Your reference: SSD-7942 MOD 1

**RESPONSE TO EXHIBITION STATE SIGNIFICANT DEVELOPMENT 7942-MOD-1  
Construction and operation of an open water surf sports lagoon facility  
Pod B, P5 Car Park, Hill Road, Sydney Olympic Park (Lot 71 DP 1191648)**

BASIN - HORIZONTAL ILLUMINANCE CALCULATION AND OBTRUSIVE LIGHTING CALCULATION POINTS

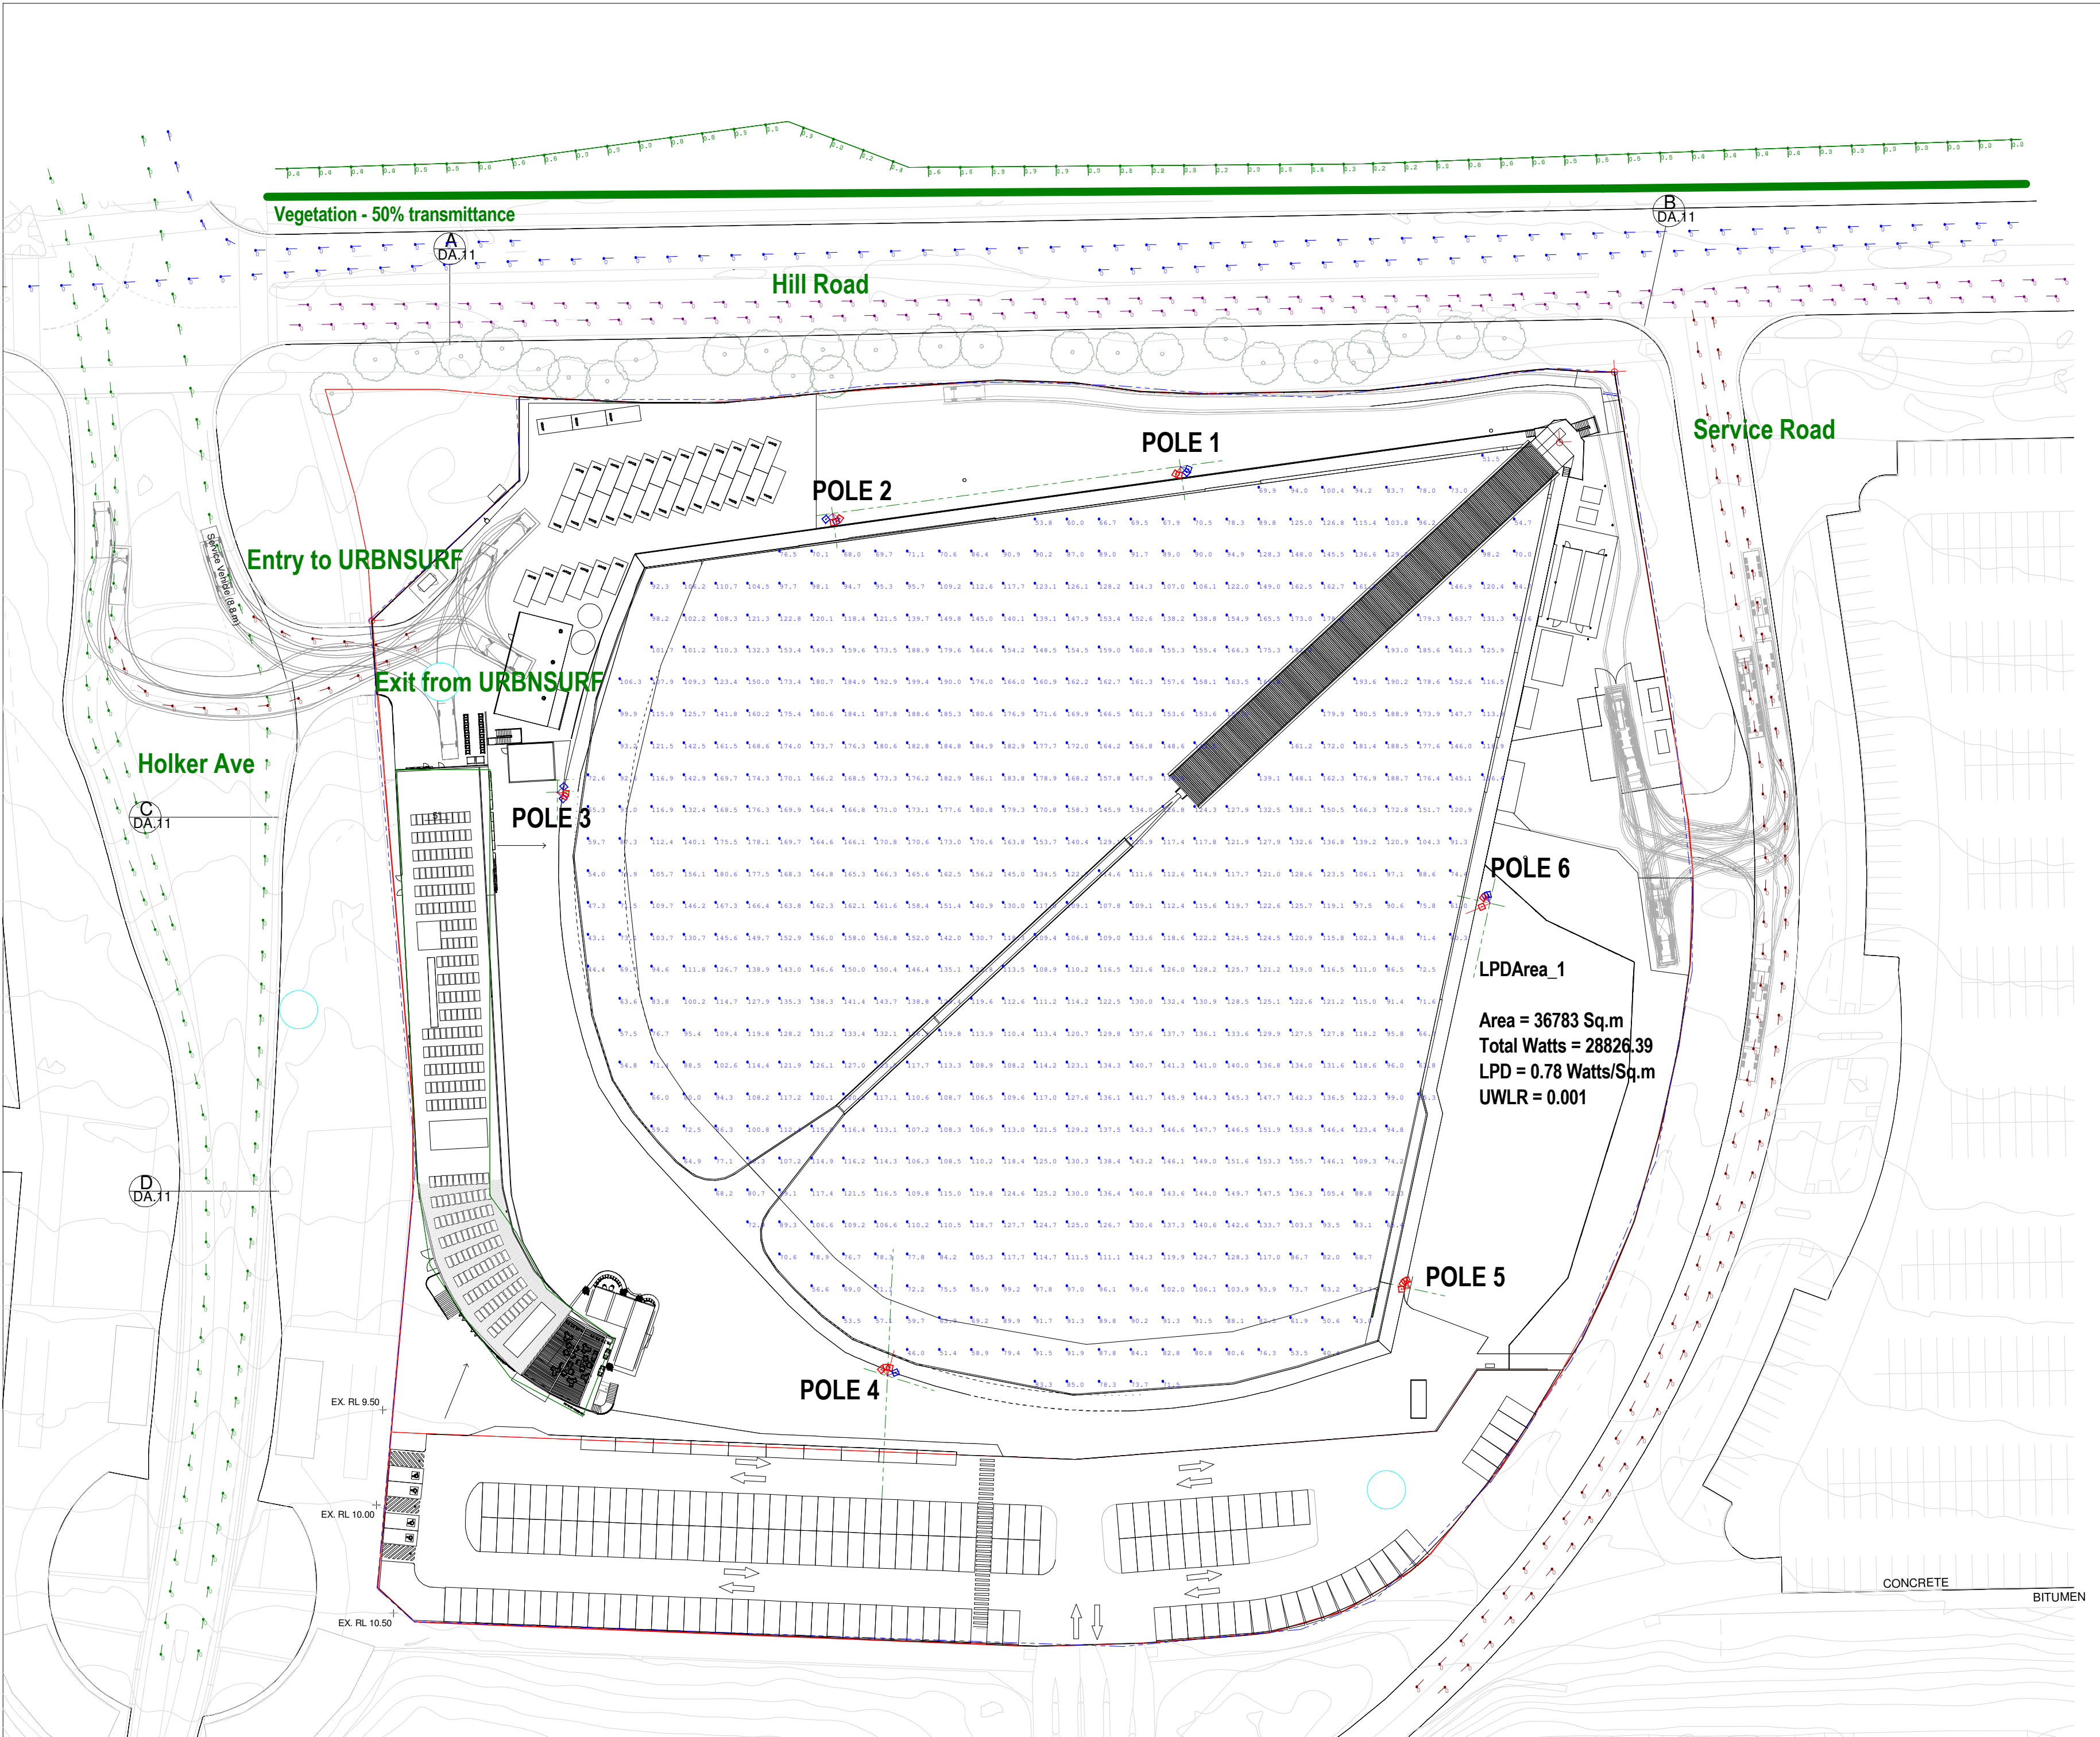
SOPA does not support the proposed extension of operating hours from 10pm to midnight due to the impact from noise and light spill on the residents of Newington who are the nearest sensitive receivers.

Furthermore, the proposed facility is located within the Millennium Parklands and sits on a nocturnal flight path between Haslams Creek and Newington Nature Reserve. Consequently, night-time noise and light impacts need to be sensitively managed so as to not impact on nocturnal fauna.

Noise and light restrictions within the Parklands are therefore required to be more rigorous than in the town centre. Currently, there are no uses operating in the Parklands beyond 10pm and the documentation submitted with the modification request does not sufficiently demonstrate that the light and noise impacts from the extended operating hours can be satisfactorily mitigated.

RE: Tree Removal

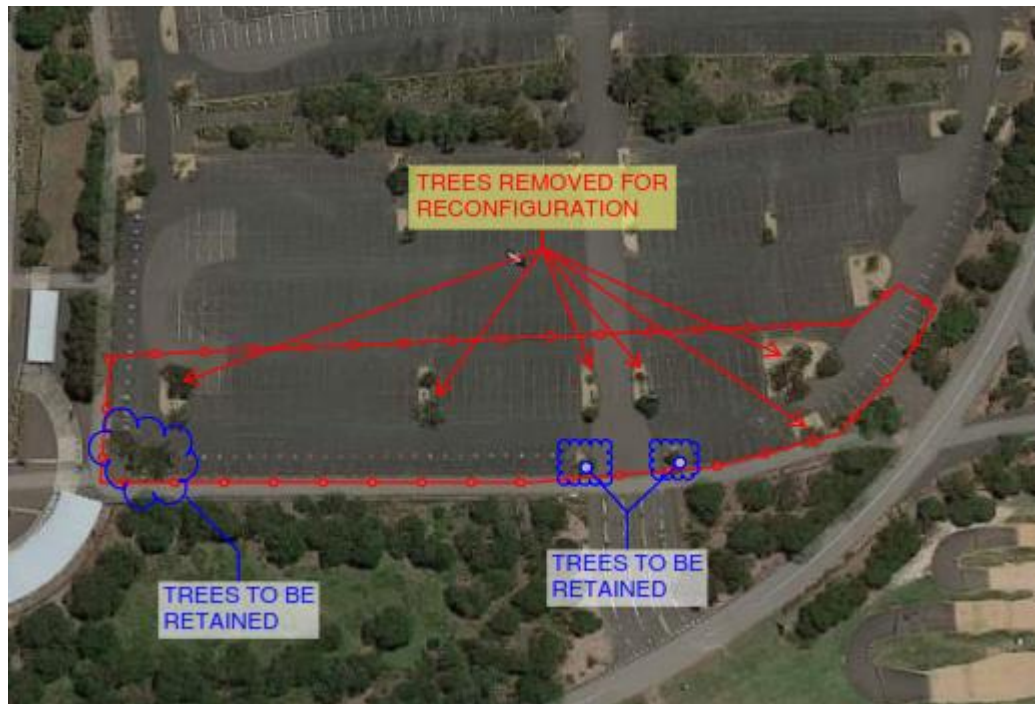
SOPA considers that the removal of the eight trees in the car park to the south of the site to facilitate additional car parking is not justified in this instance. The proposal already includes significant tree loss to facilitate the wave park. Whilst the loss of trees were considered justified in the assessment of the original SSD, the removal of eight additional trees in this modification to facilitate additional car parking without significant off-set or retention is contrary to current and draft policies for Sydney Olympic Park, Greater Sydney and NSW. Of note, the following policies are relevant and should be taken into consideration in the assessment and justification of this SSD modification:

The proponent should seek to adopt a maximum tree retention methodology for the car park and review the car-parking layout to maximise tree retention. Furthermore, the removal of any additional trees at the site should be fully supported by an Arborist Report and where tree retention is unavoidable; replacement tree planting measures should be detailed.

3. South-West Elevation
Scale 1 : 200

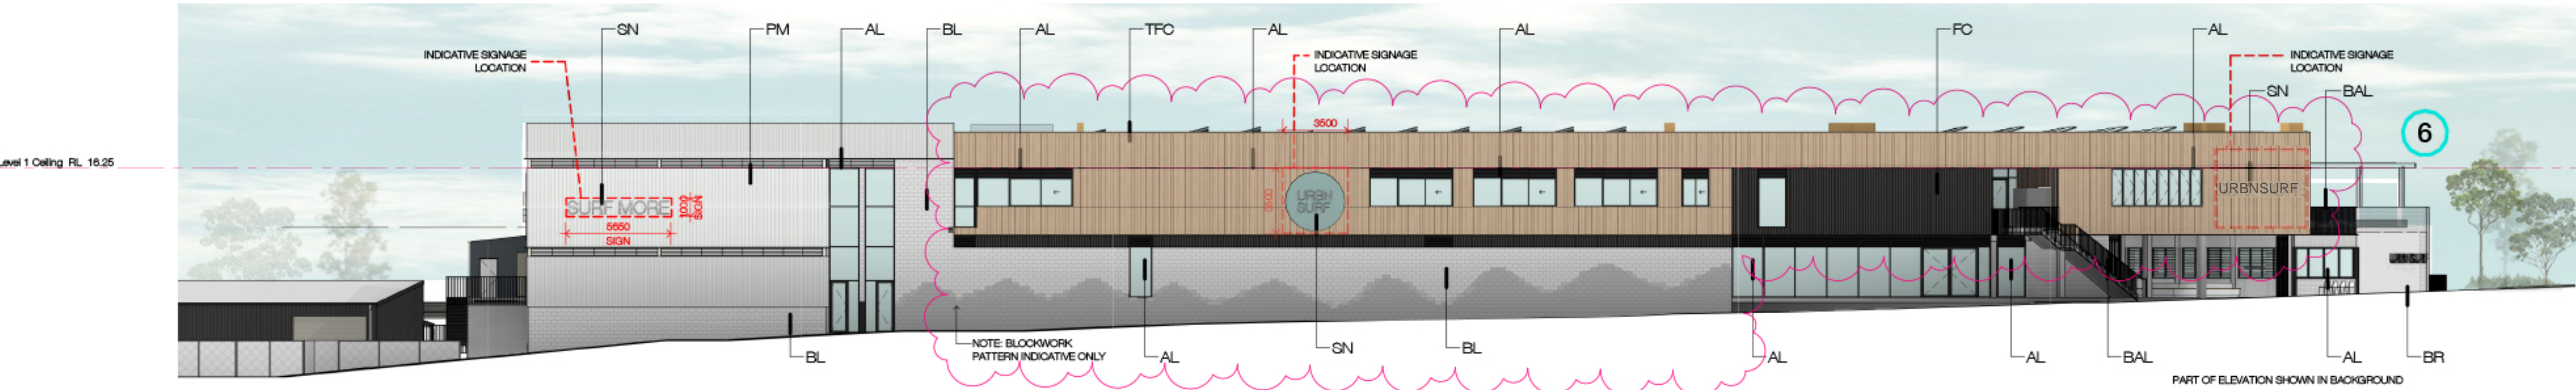
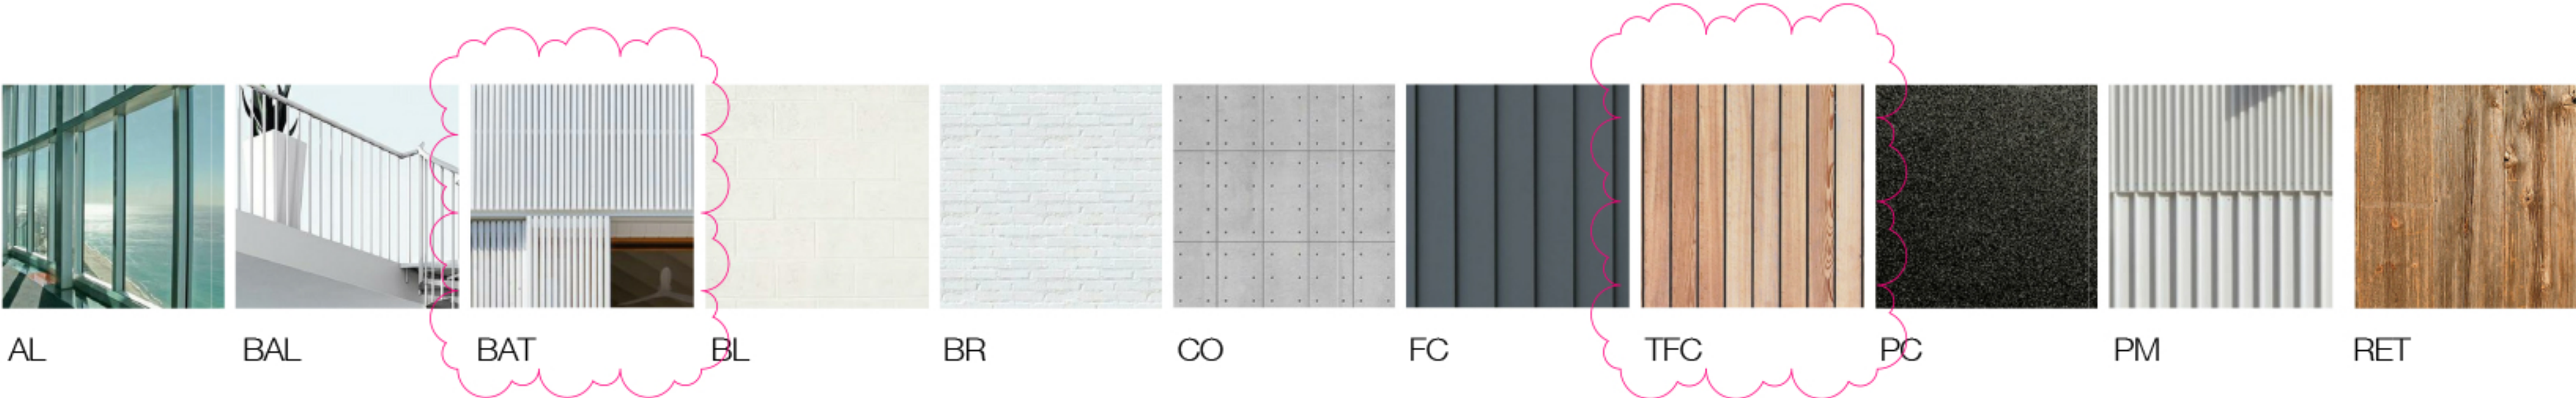
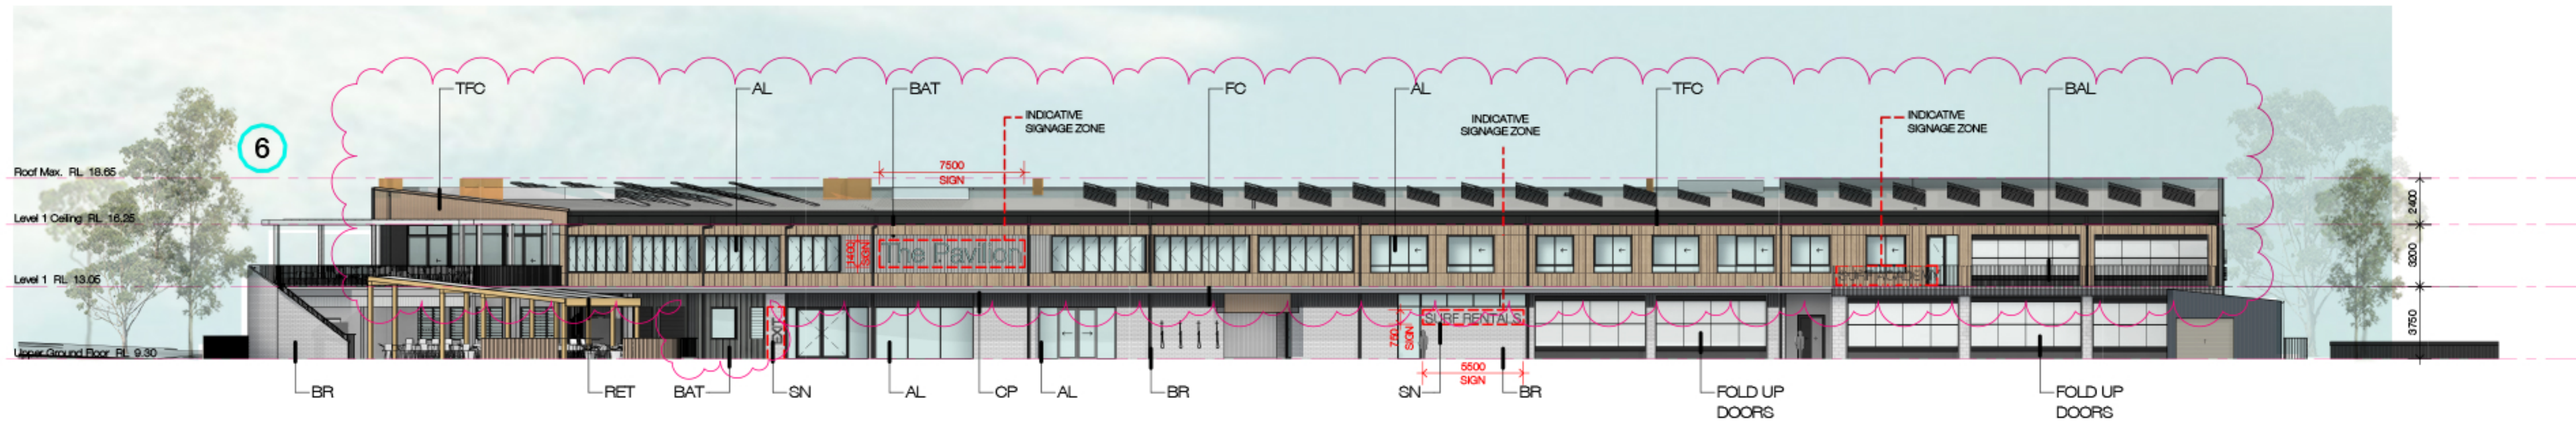
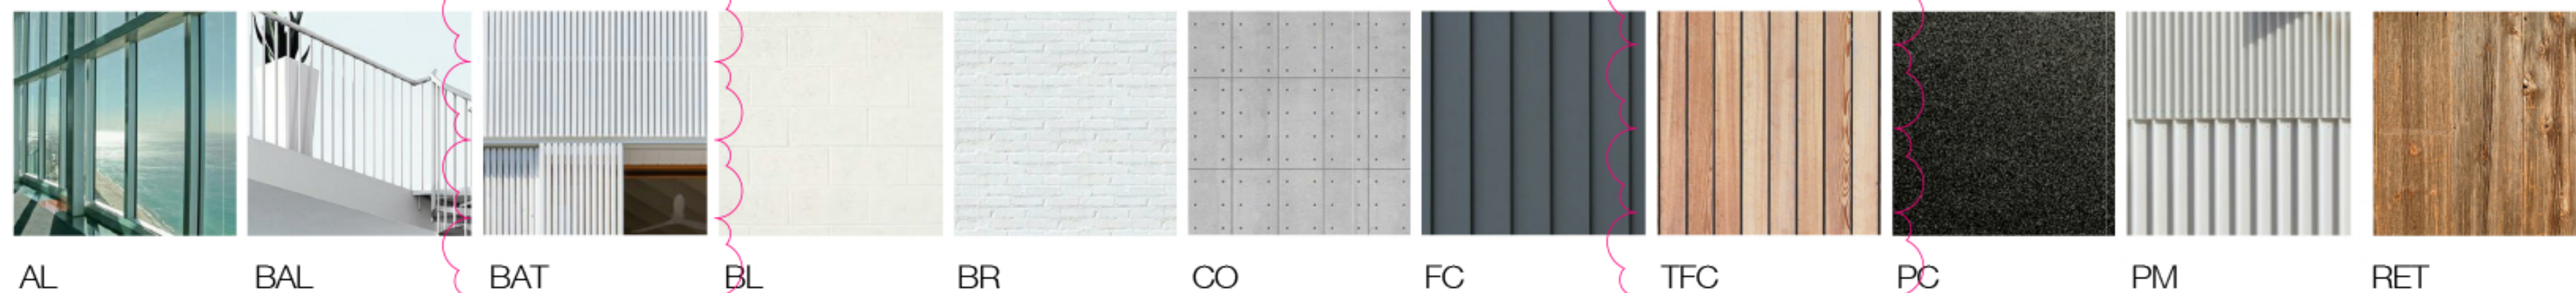
However, SOPA considers that the materiality and colour of the proposed building facade, given the location of the development site within Sydney Olympic Park Parklands, should be more reflective of the site's location and incorporate natural materials and neutral colours. In particular, the dark tones and large amounts of the proposed modified cladding and loss of the warm-toned timber cladding is not appropriate to the setting.

Accordingly, SOPA considers the modified design in relation to materials and colours of the façade are unacceptable and the original colours and materials should be revisited.
